Rezoning Transportation Analysis
Petition Number: Insert Zoning Petition #2020-184
General Location Identifier: 06703101

Revision Log:	Date	Description
	01-21-2020	First Review (KP)

Transportation Summary

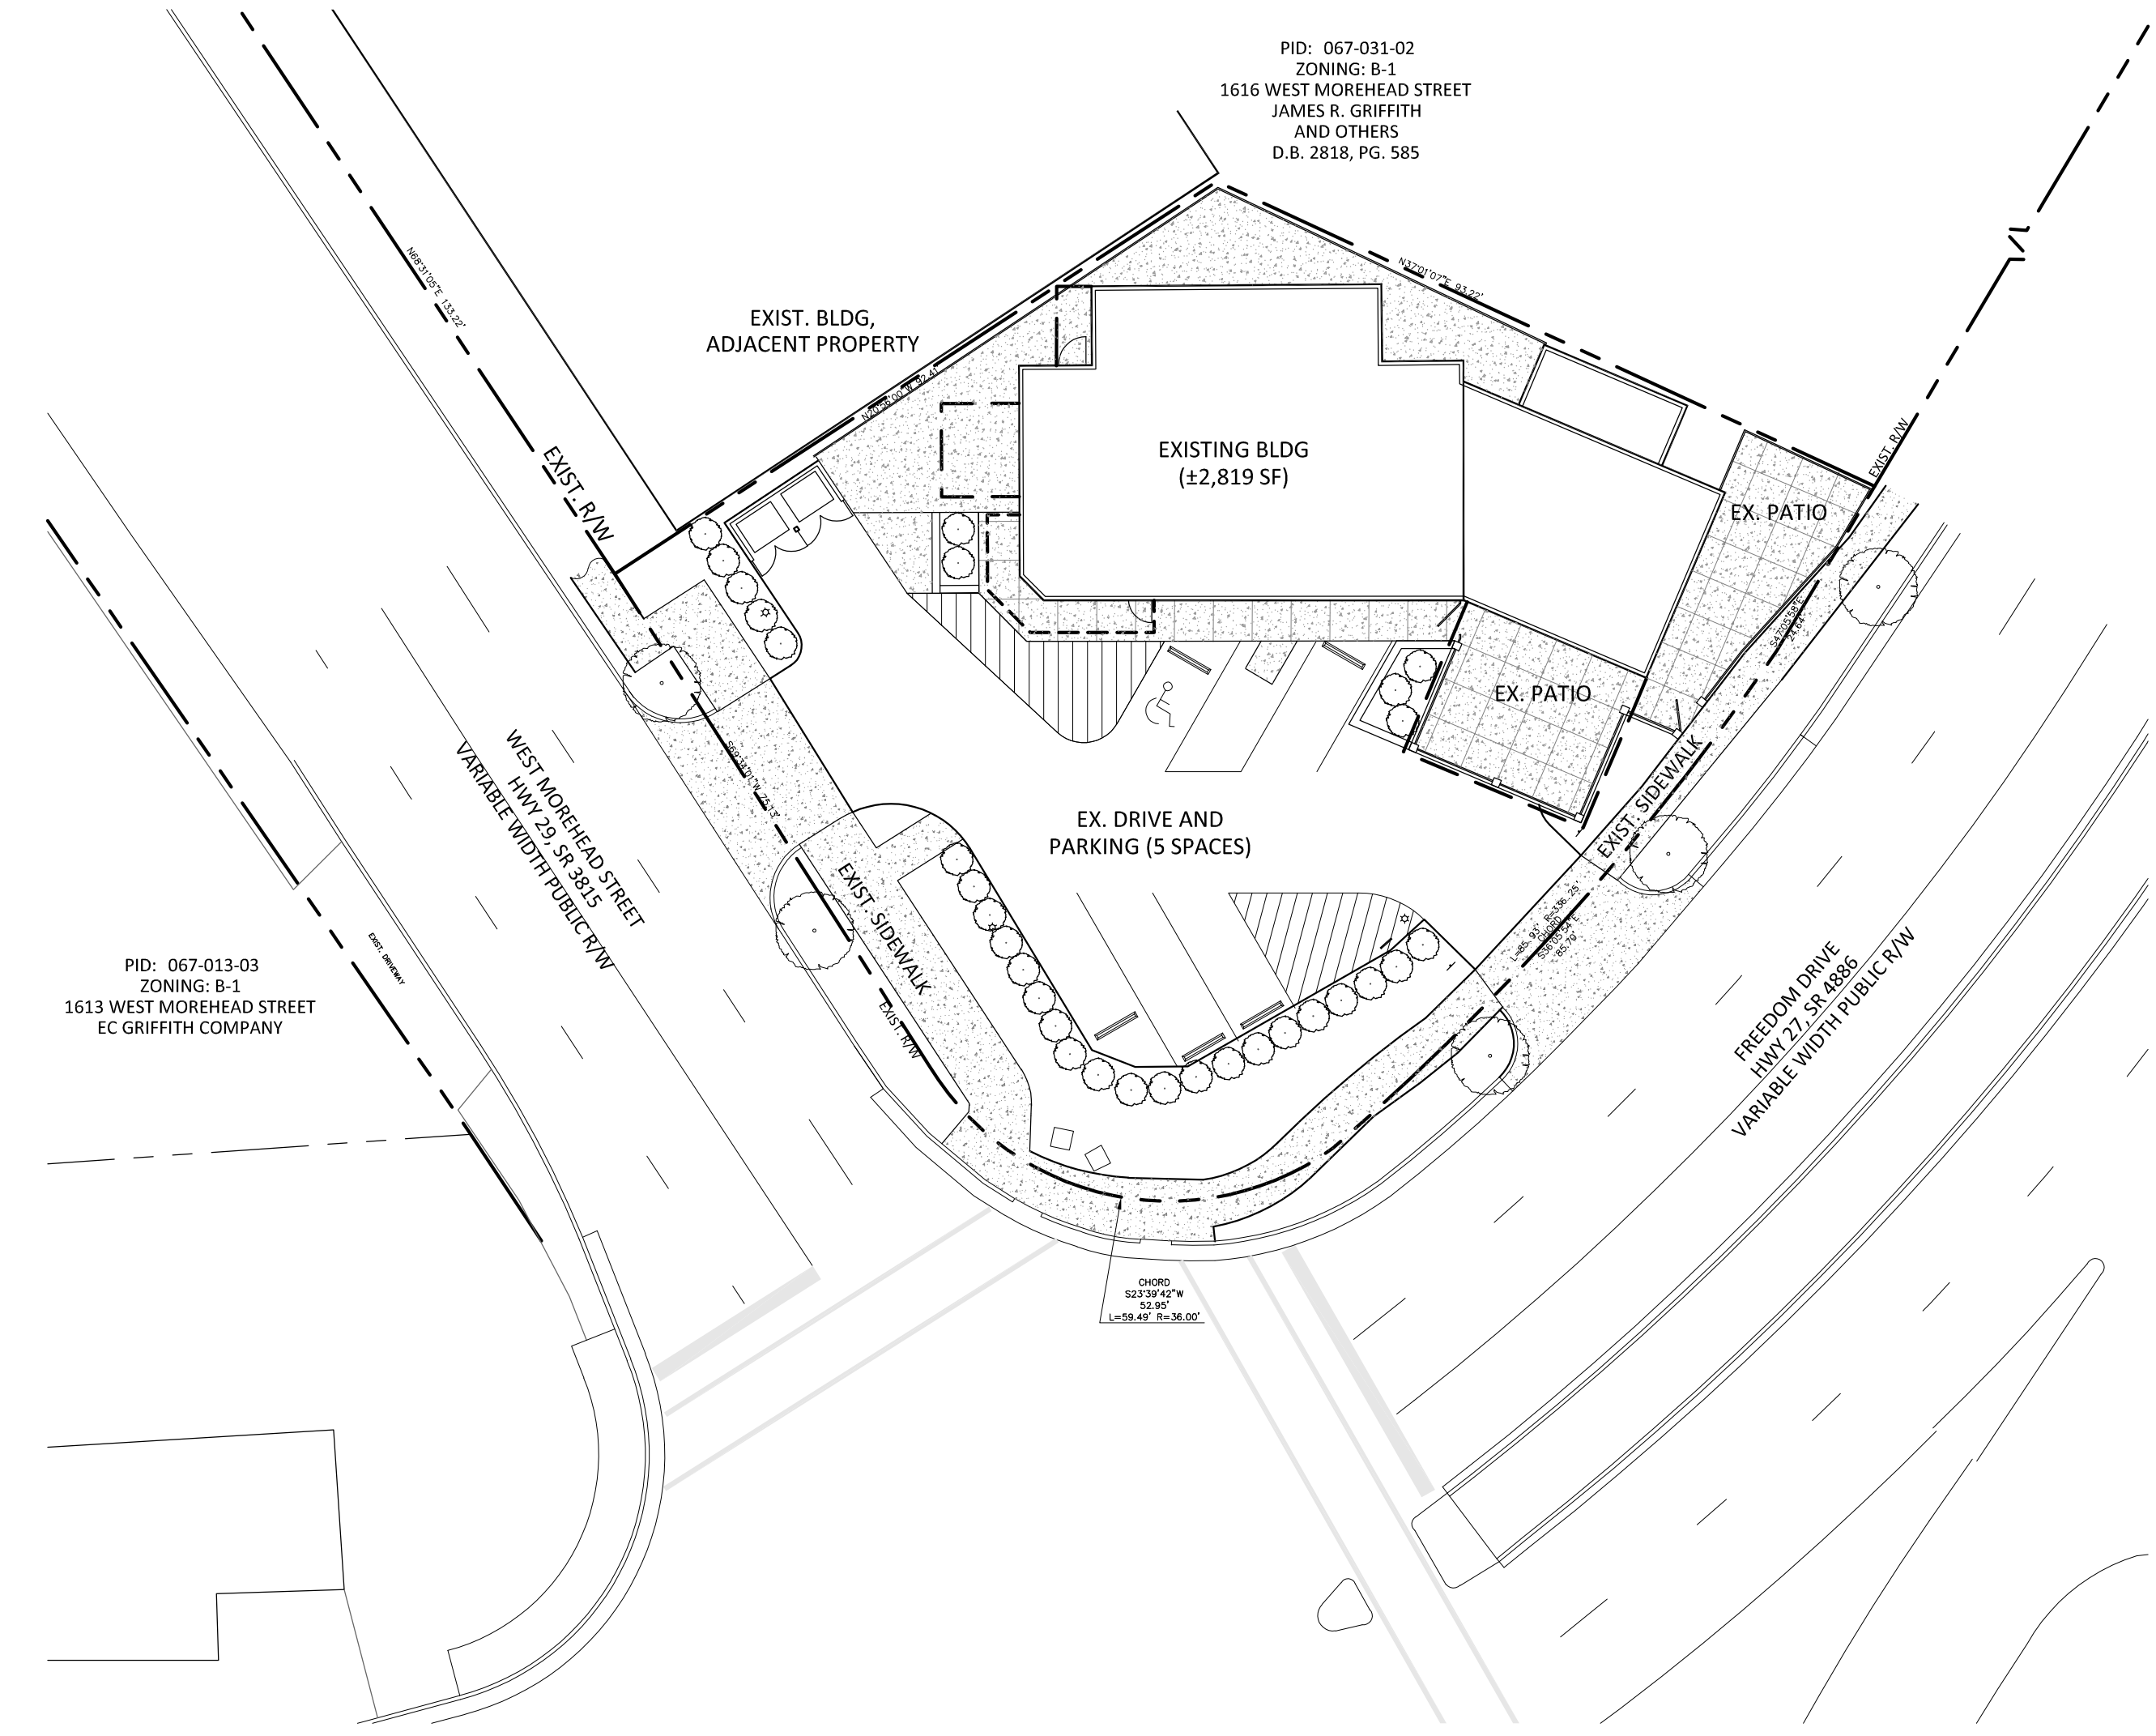
1. Revise the site plan by adding a sidewalk utility easement 2-feet behind the sidewalk along the site's Morehead Street and Freedom Drive frontage.
2. Revise the site plan by correcting the West Morehead Street pavement markings.

3. A site plan note(s) specifying dedication and fee simple conveyance of all rights-of-way to NCDOT before the site's first building certificate of occupancy is issued is needed. CDOT requests rights-of-way set at 2' behind back of sidewalk where feasible.
